Our Case Number: ACP-323851-25

Re: Proposed construction of the Celbridge Hazelhatch Mobility Corridor
Celbridge Town, County Kildare

RE: Celbridge Hazelhatch Mobility Corridor Application, Case Ref: JP09.323851

DRAINAGE
SURFACE WATER LAYOUT

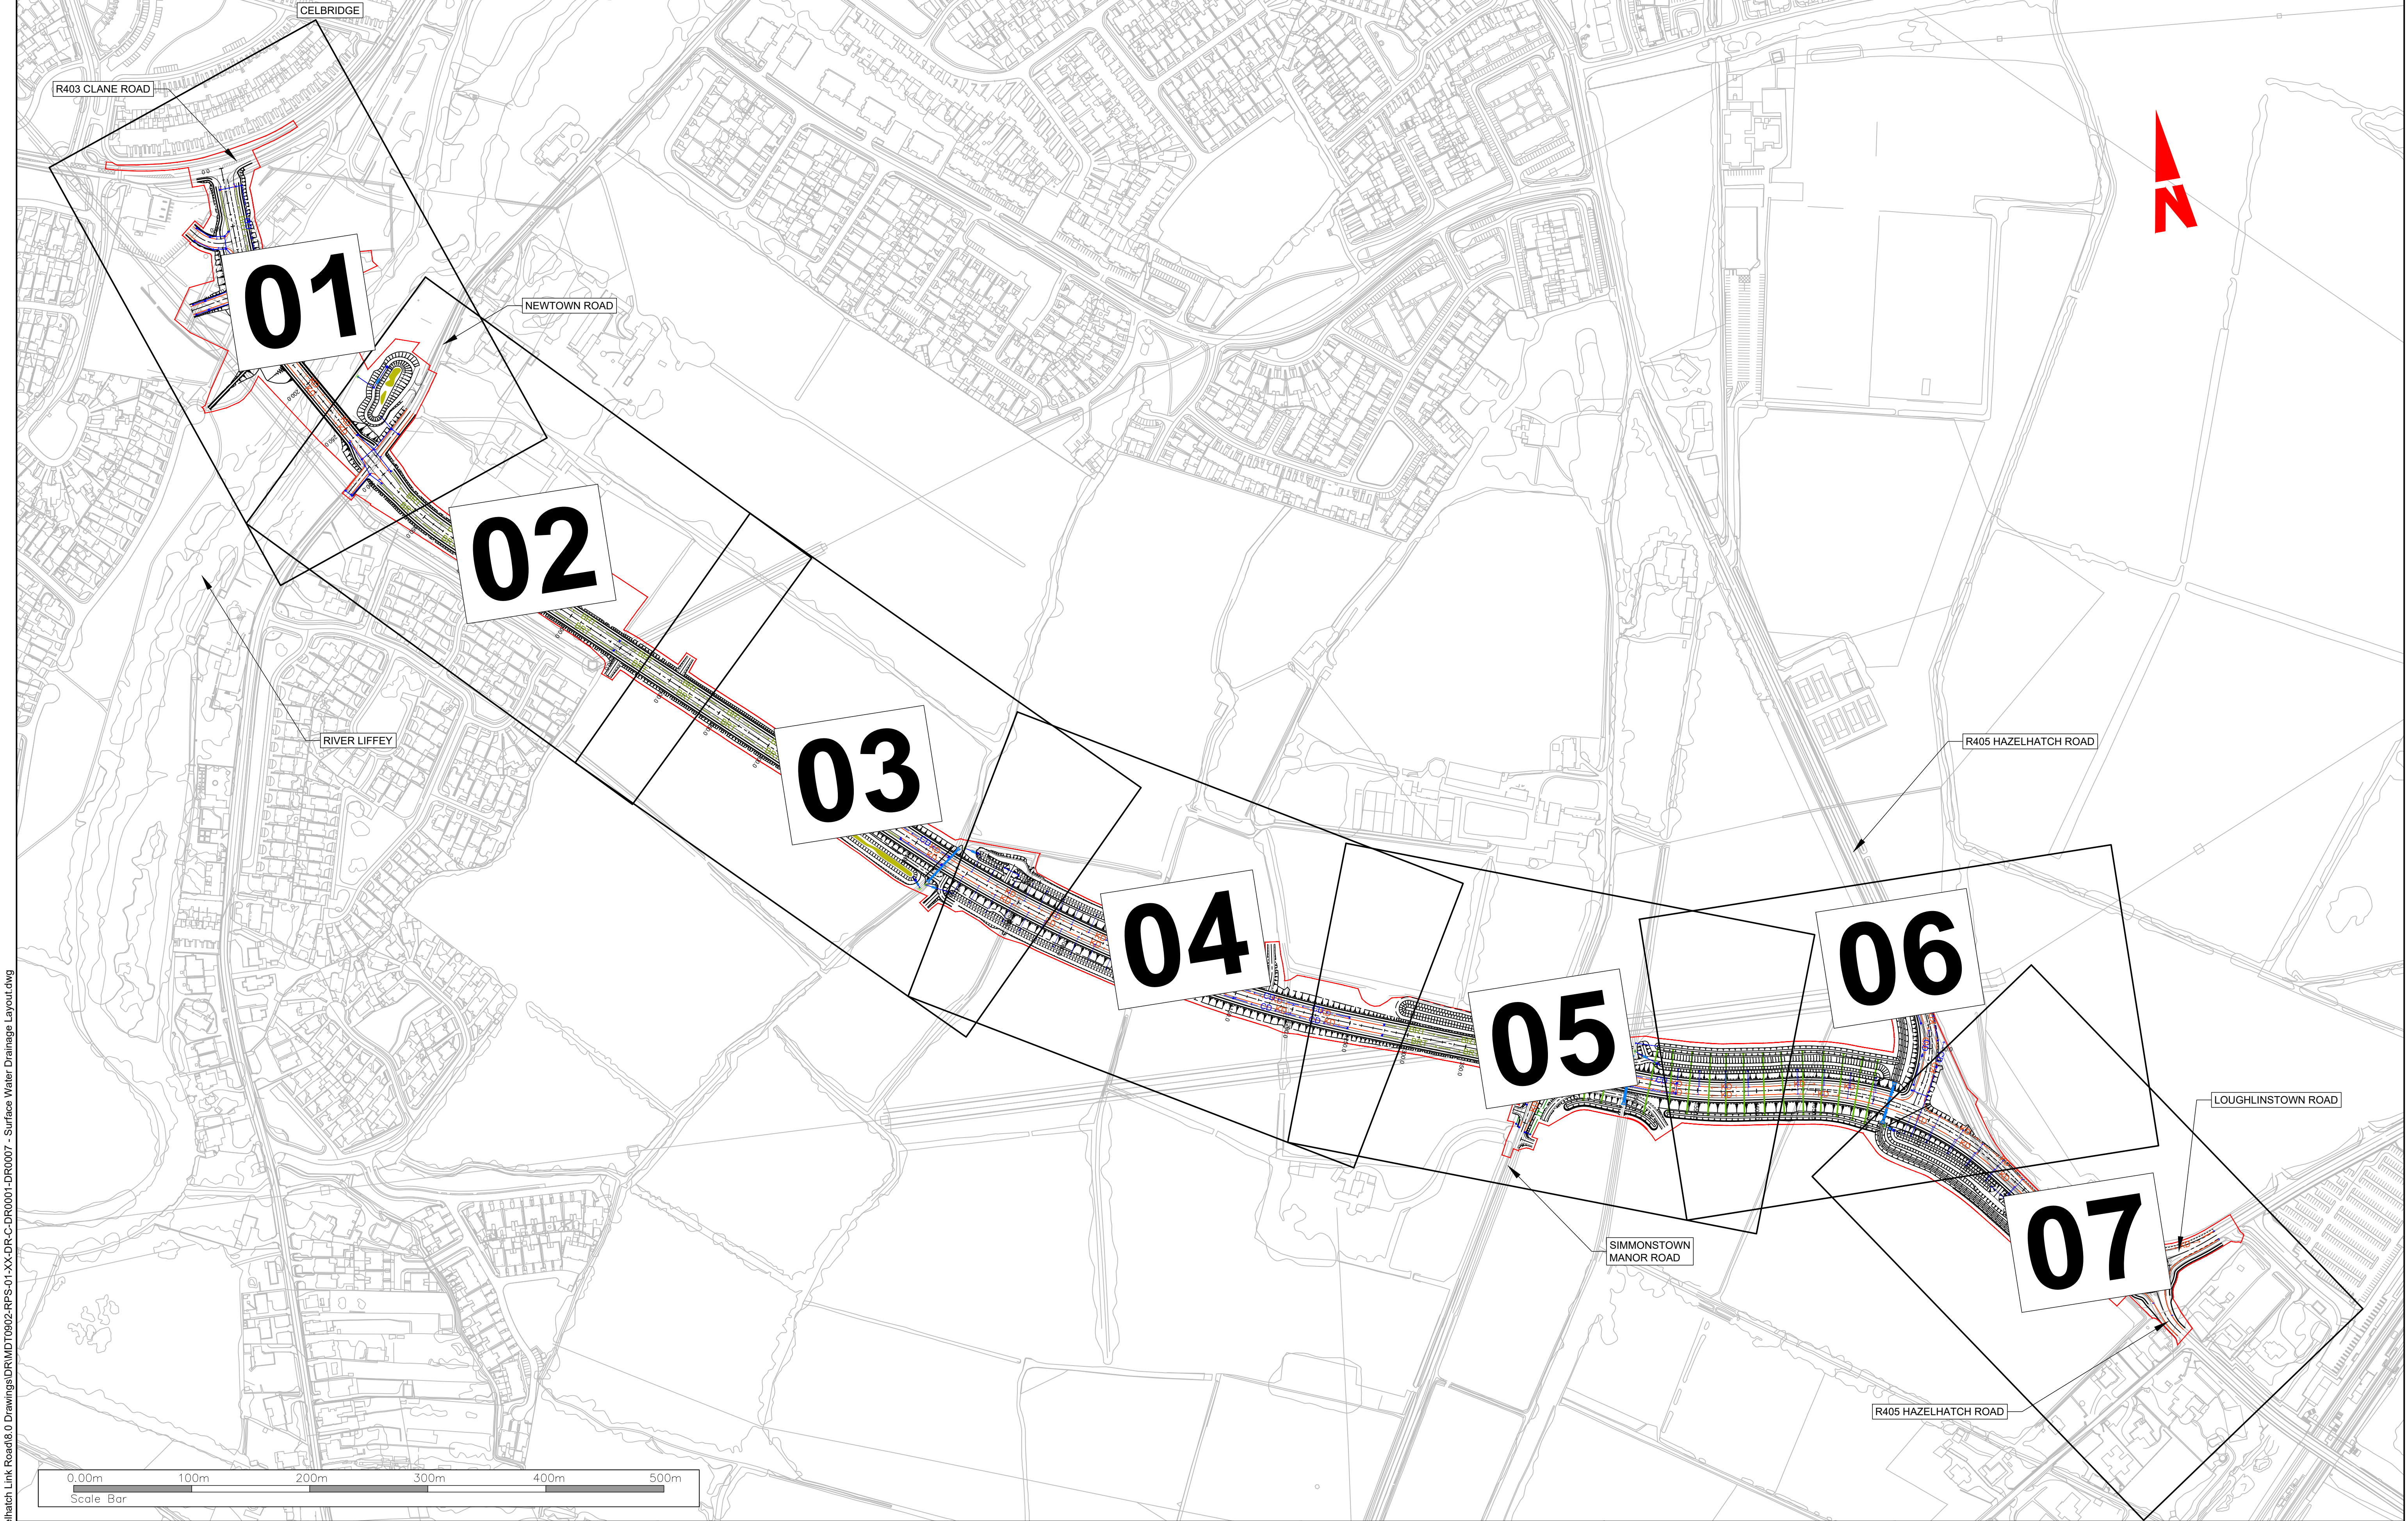
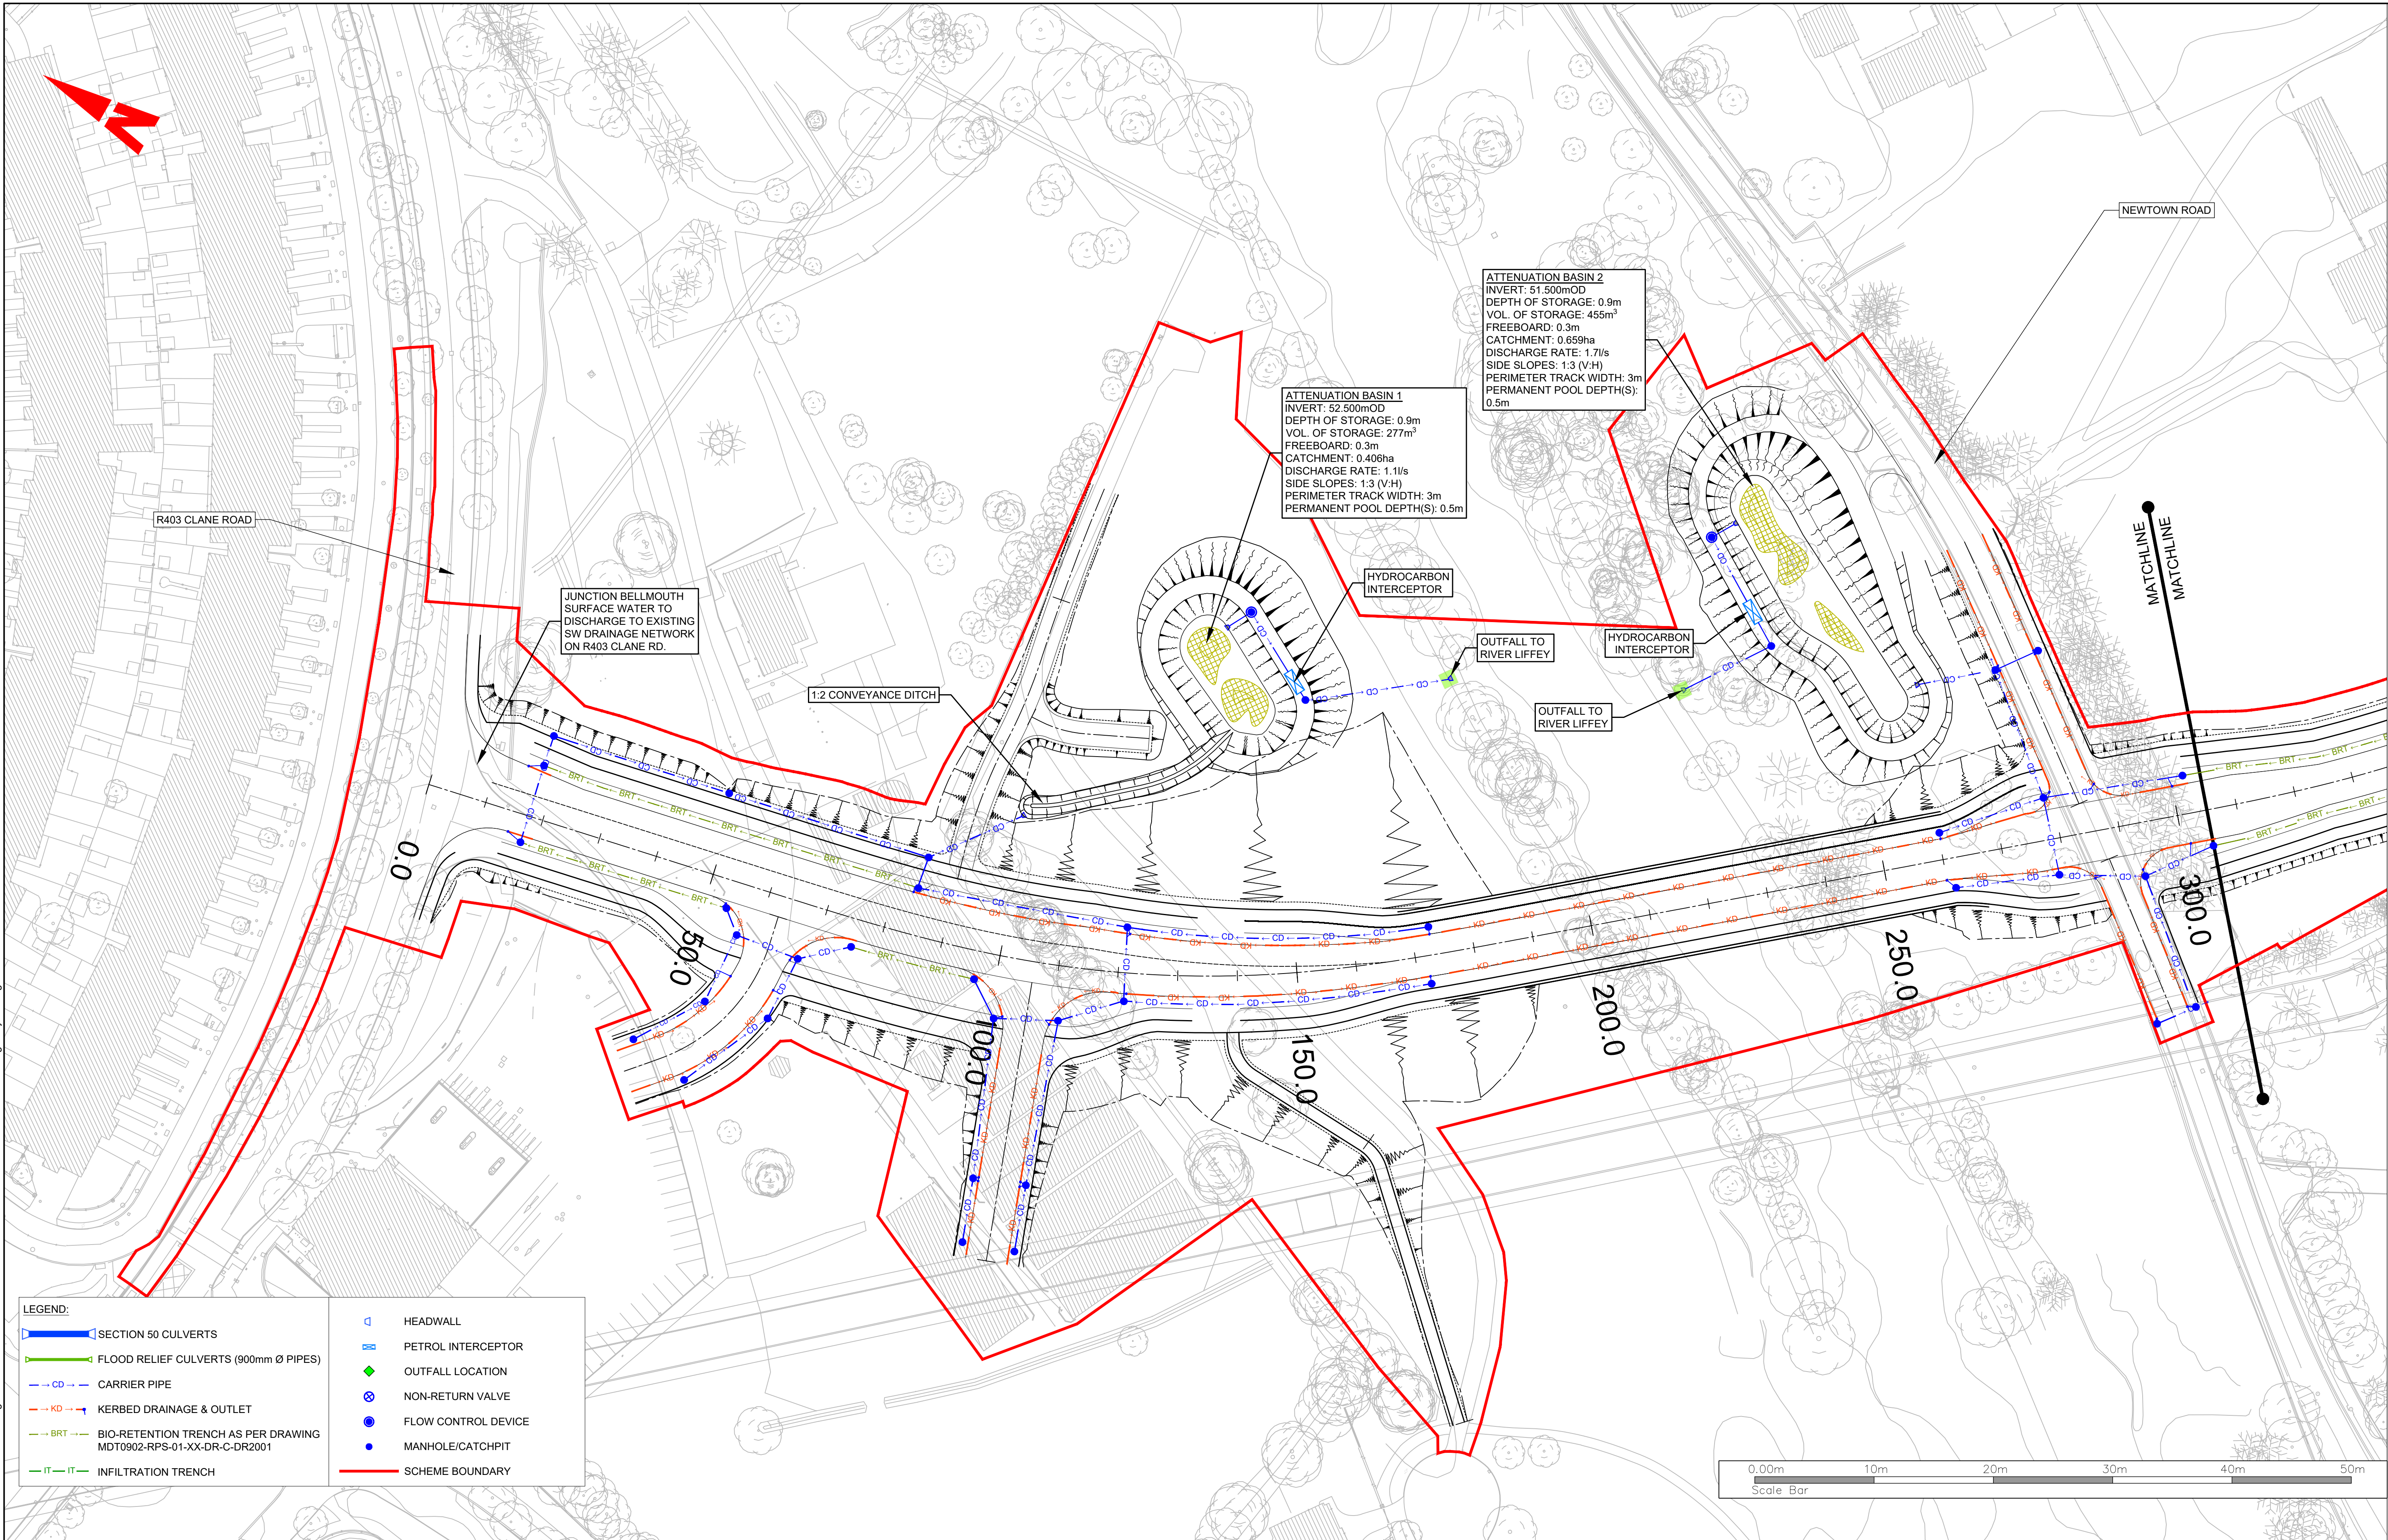
It is our opinion that the stormwater management strategy for the Mobility Corridor, incorporating linear stormwater channels and storage features, should be reviewed so as not to impact adjacent proper development. The current design has swales on both sides of the corridor. This is not conducive to a streetscape and should be reconsidered.

There are a number of attenuation basins and swales located on both sides of the Mobility Corridor. While it is acknowledged that these features are necessary for the construction of the Mobility Corridor, it is suggested that their layout and extent be reviewed in light of their potential impact on future residential development frontages. As currently proposed, the location of the basins and swales would push back potential residential building lines from the road edge, in some instances by up to 20m.

In this context, the current extent and positioning of the proposed attenuation basins and swales along the Mobility Corridor may conflict with DMURS principles by increasing the separation between the carriageway and future development plots. This could result in recessed building lines, reduced enclosure and a diminished opportunity to deliver active frontages along the corridor. A review of the layout, scale, and continuity of these features is therefore suggested to ensure alignment with DMURS objectives and to support the creation of a legible street that balances movement with placemaking.
